Our ref: DOC21/389266

Senders ref: SSD 8865 Mod 1 (Liverpool)

Subject: St Anthony of Padua Catholic School MOD 1, 125-165 Tenth Avenue and 140-170 Eleventh Avenue, Austral (SSD 8865)

LANDSCAPE MASTER PLAN - PROPOSED PLANTING SCHEME

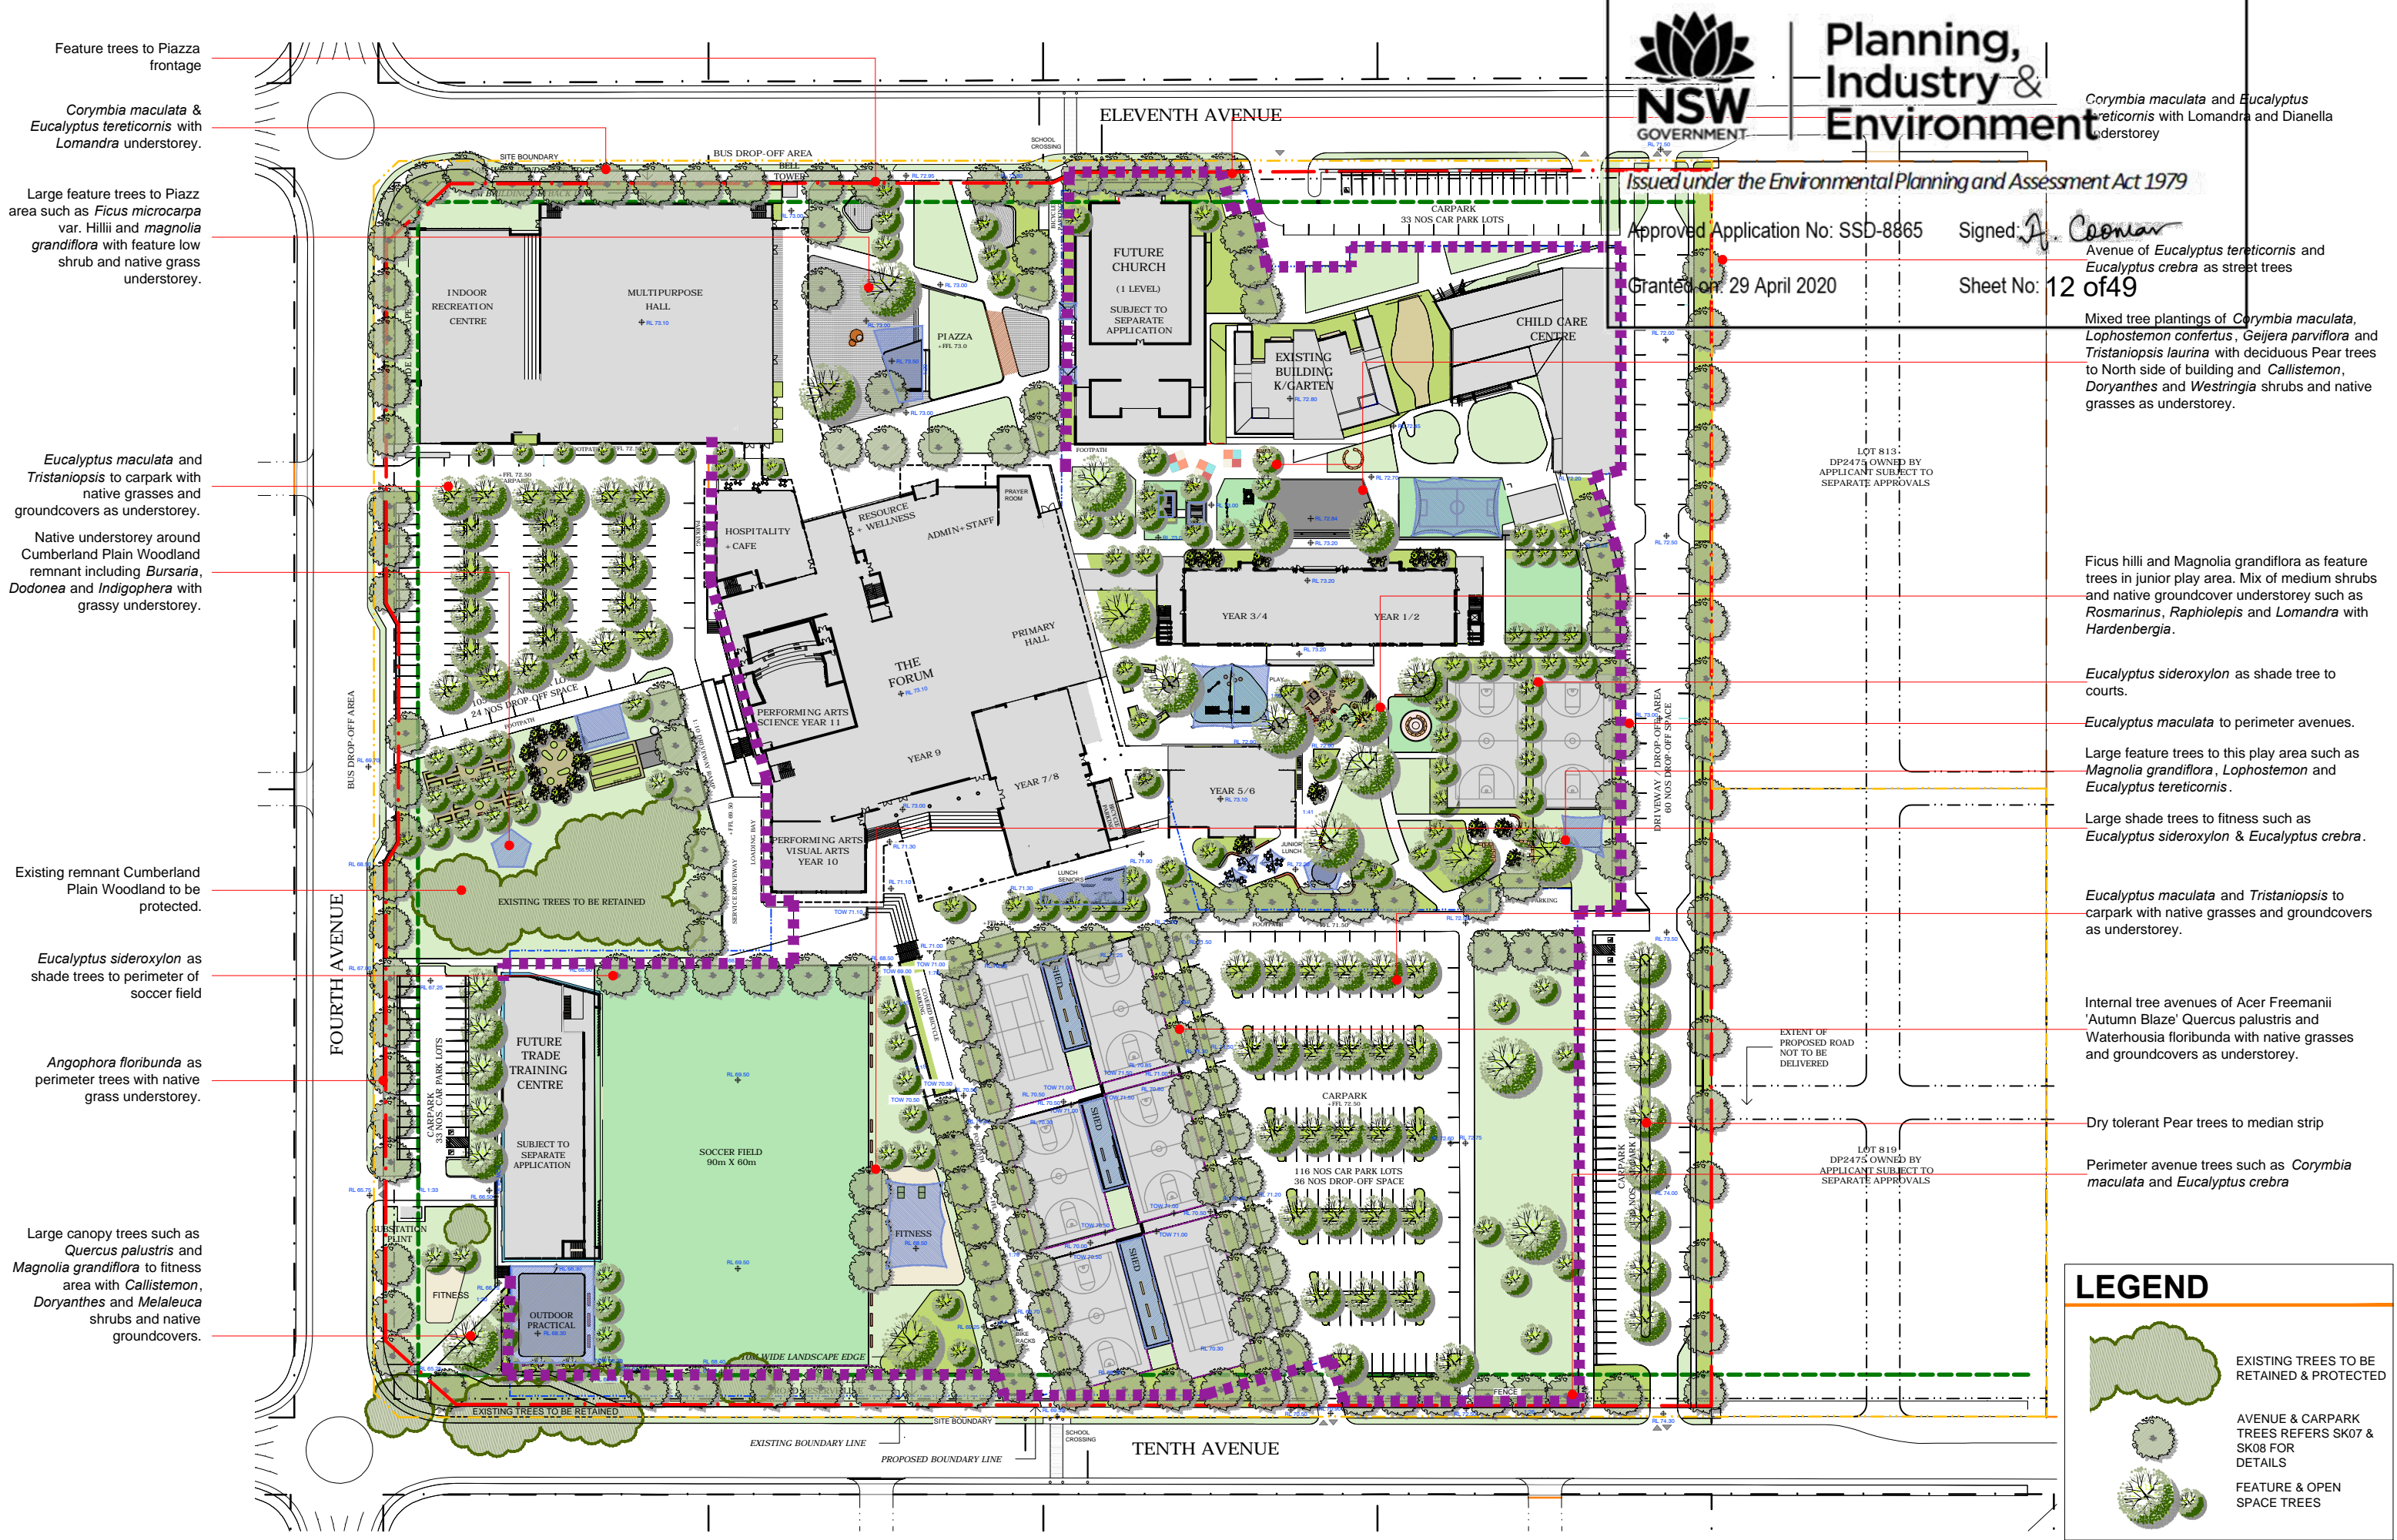
The site is biodiversity certified. EES's previous comments were in relation to species selection for landscaping. According to the Landscape Master Plan on the website for this modification, the planting schedule includes a number of CPW species, and therefore is considered to be satisfactory.
